REF: Pier/ Footing Inspection
Chase Banker, Res.
6075 McDougald Rd
Lillington, NC 27546
Michael Gannon, Contractor
Permit# SFD 2008-0058

DESIGN PROFESSIONAL INSPECTION FORM

Residential Single-Family Project: <input checked="" type="radio"/> N	Commercial Project: Y <input checked="" type="radio"/> N
Code Enforcement Project No:	Permit No: SFD 2008-0058
Project Name: Banker Residence	Owner: Chase Banker
Project Address: 6075 McDougald Rd, Lillington, NC 27546	Suite No:
Date Inspected: Nov 1, 2021	Contractor Name: Michael Gannon
Component Inspected: Pier & Footing Placement

FOUNDATION PLAN

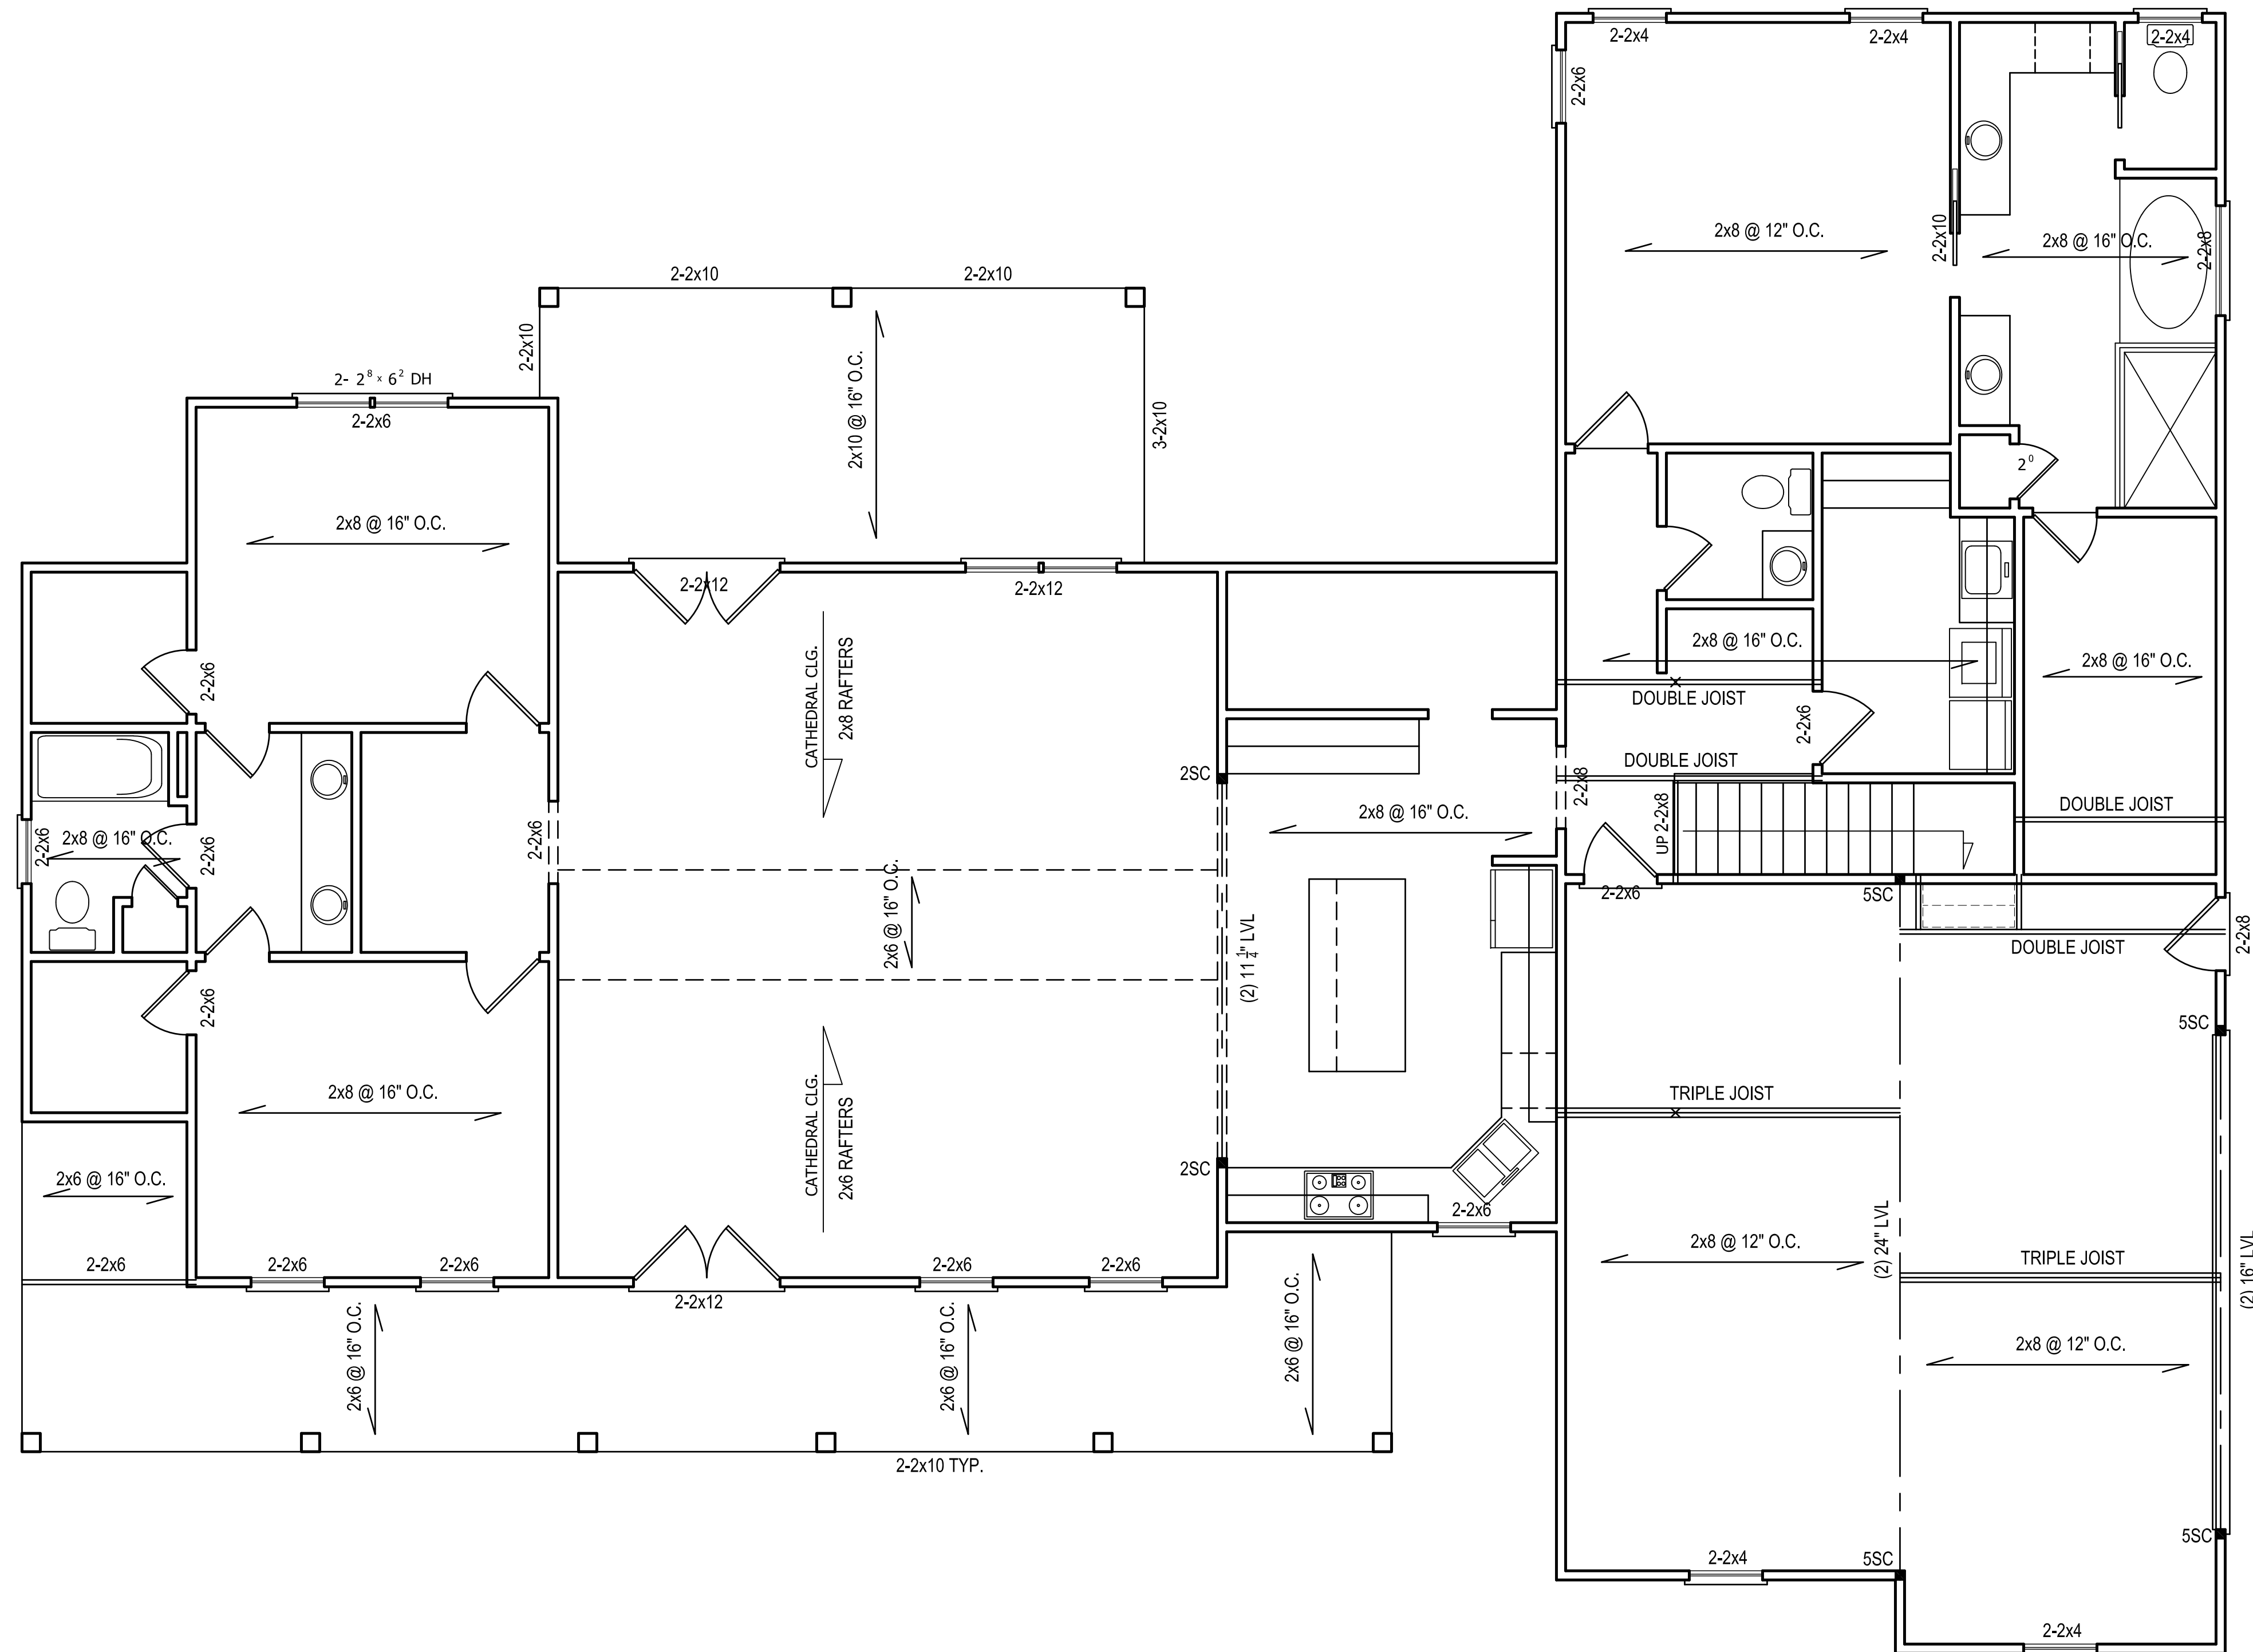
I made an onsite visit to the residence referenced above on November 1, 2021. The purpose of the visit was to examine four Footing with Piers. The 16"x16" piers were not placed in the middle 1/3 of the 24"x24" x 10" Footing. There was adequate Projection on the short side of the footings.

Because of the size and depth of the footings and the size of the piers and with the small amount of loading, I have no problem approving the four Pier/Footings as built.

The Piers/ Footings will support the required loading as specified in the North Carolina State Residential Building Code. 2018,ed.
